Our Ref: SAG001
Your Ref: 23/01316/F

26th May 2023

Erection of 5 two storey age restricted dwellings (55 years) for older people with access, landscaping and associated infrastructure - Land South of Faraday House, Woodway Road, Sibford Ferris (Application No. 23/01316/F)

**Figure 4 – Proposed Site Plan**

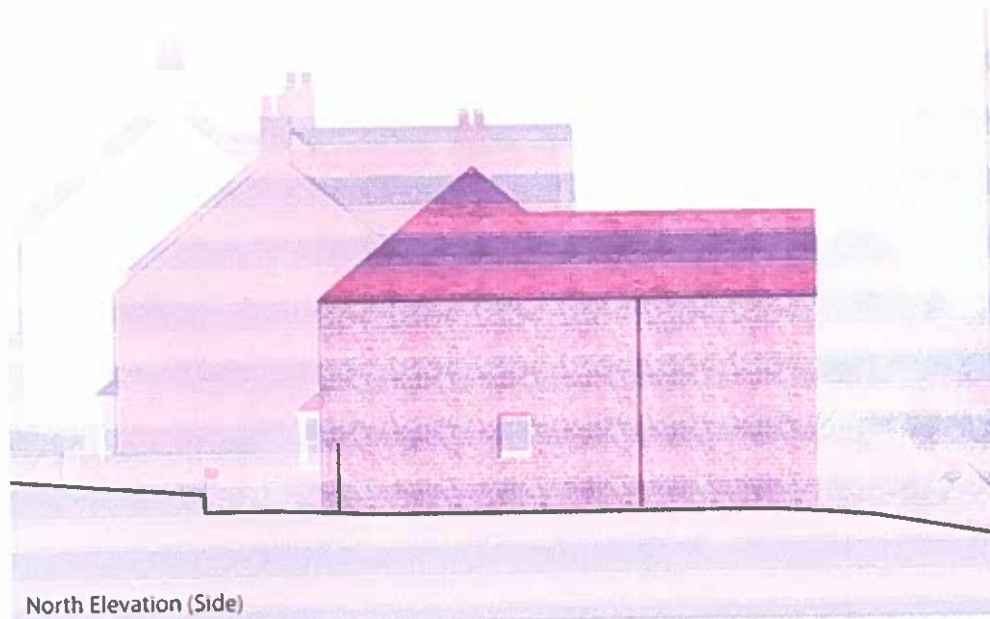
Outlook is important as a dwelling without a reasonable outlook is an undesirable place to live. This is even more important and critical in village locations in rural areas where there is a loose-knit pattern of development and residents have become accustomed to having an open outlook onto fields and the countryside beyond. Whilst the planning system operates in the public interest and does not protect private views, it is not unreasonable for proposed development to respect existing residential amenities, deliver suitable living conditions and maintain an acceptable outlook. The close proximity of the proposal to existing dwellings is evident from Figure 4, although it should be noted that Butwick House lies to the north of Bramley House, not to the south.

The physical impact of the dwellings – especially Plot 5 – is perhaps most acute upon Faraday House just 15 metres to the north of the site, as shown on Figure 6 taken from the application.

Figure 6 – View of Proposal from the North (Faraday House)

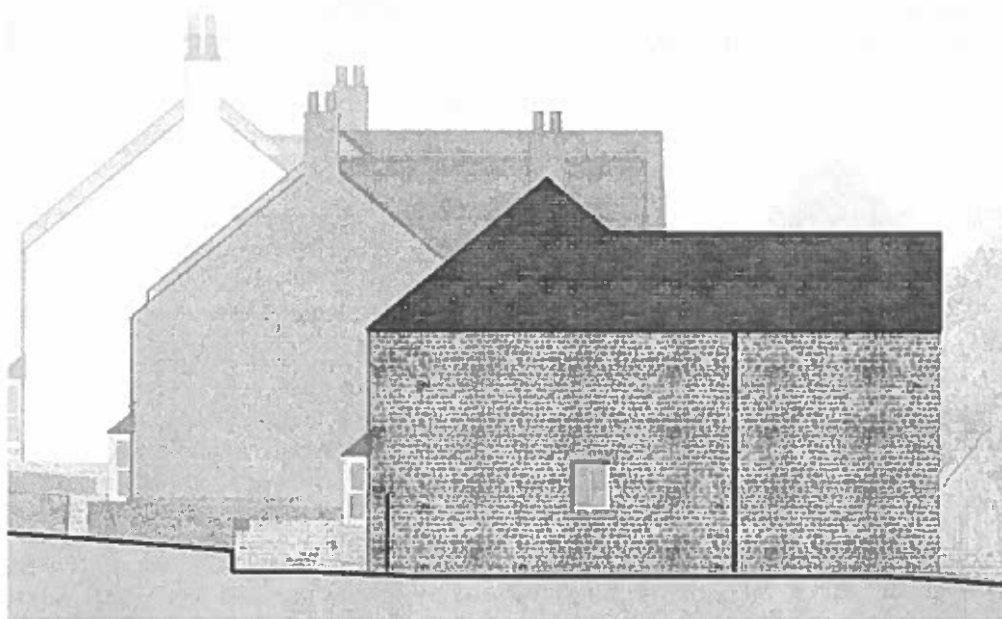
Where development results in prejudicial harm to the outlook of a residential property and is unduly overbearing it should be resisted as failing to achieve acceptable standards of layout, design and residential amenity and the highest possible standards of design.
